PINS reference TR030001

Application for the proposed Able Marine Energy Park on the south bank of the River Humber at Immingham, North Lincolnshire

Response to first stage Written Representations
in Respect of Terrestrial Ecology and
Nature Conservation

Philip Rowell BA(Hons) DipTP MRTPI MCIHT
(Adams Hendry Consulting Ltd)
on behalf of
ASSOCIATED BRITISH PORTS

Figure 2: Indicative layout of wet grassland area

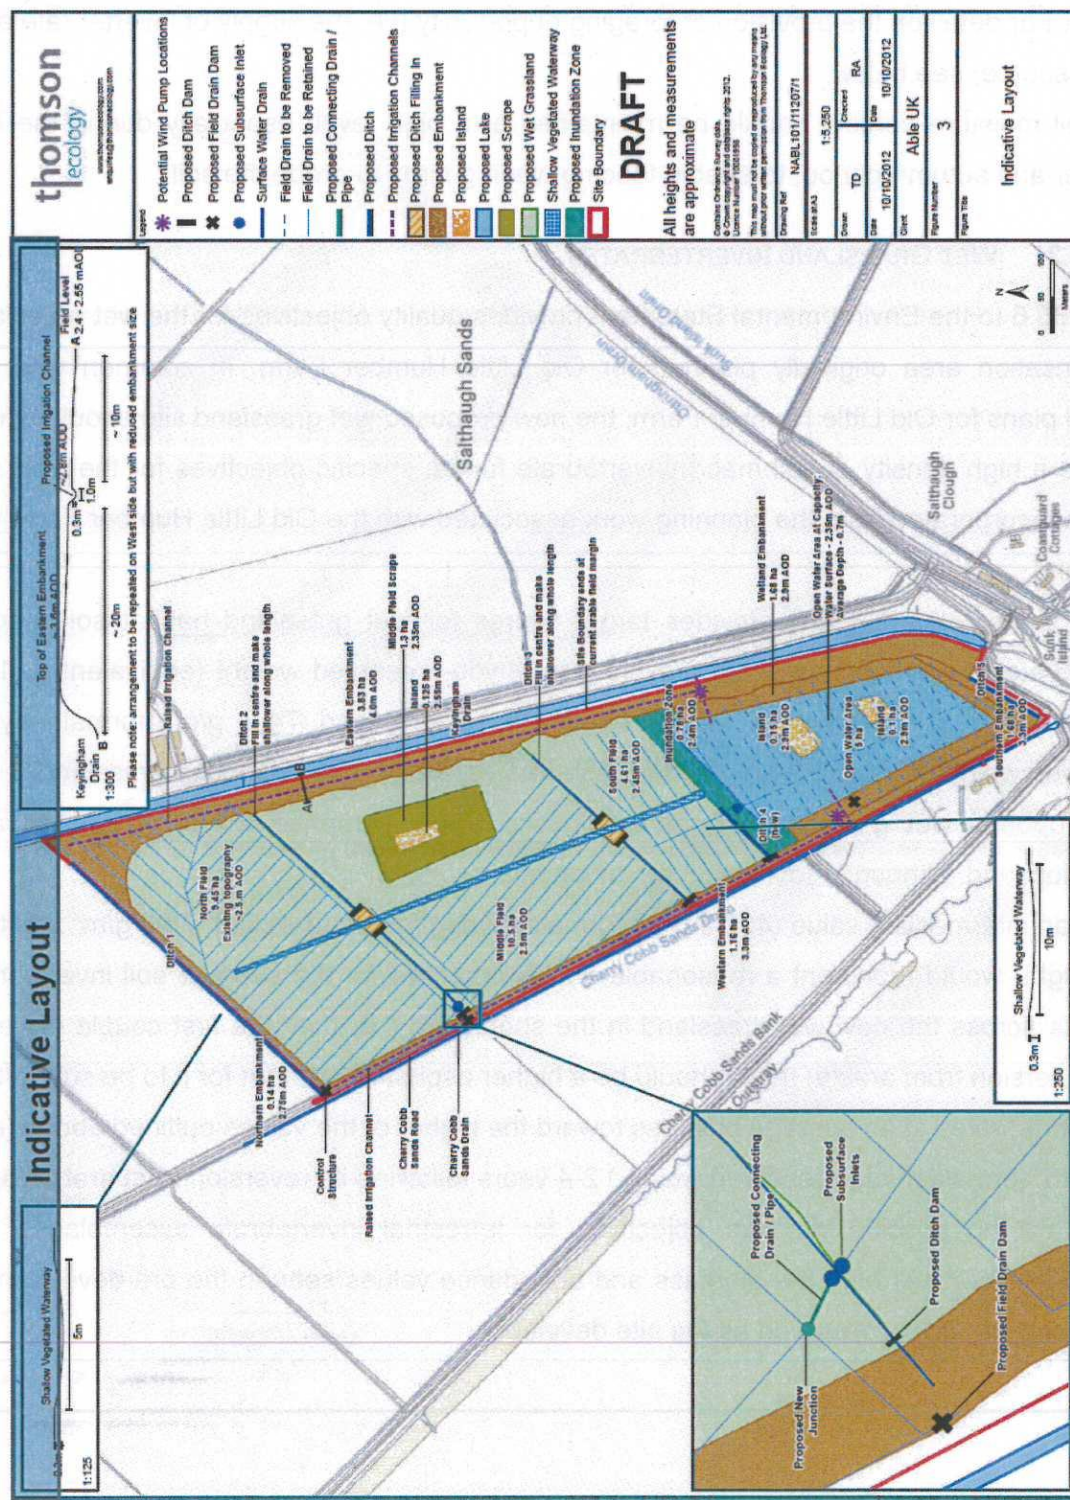
- 2.18 It should be noted that the design of the wet grassland does not include roosting areas, and so there will be no replacement of the ecological function that is provided by the close proximity of North Killingholme Haven Pits and Killingholme Marshes Foreshore (see below).
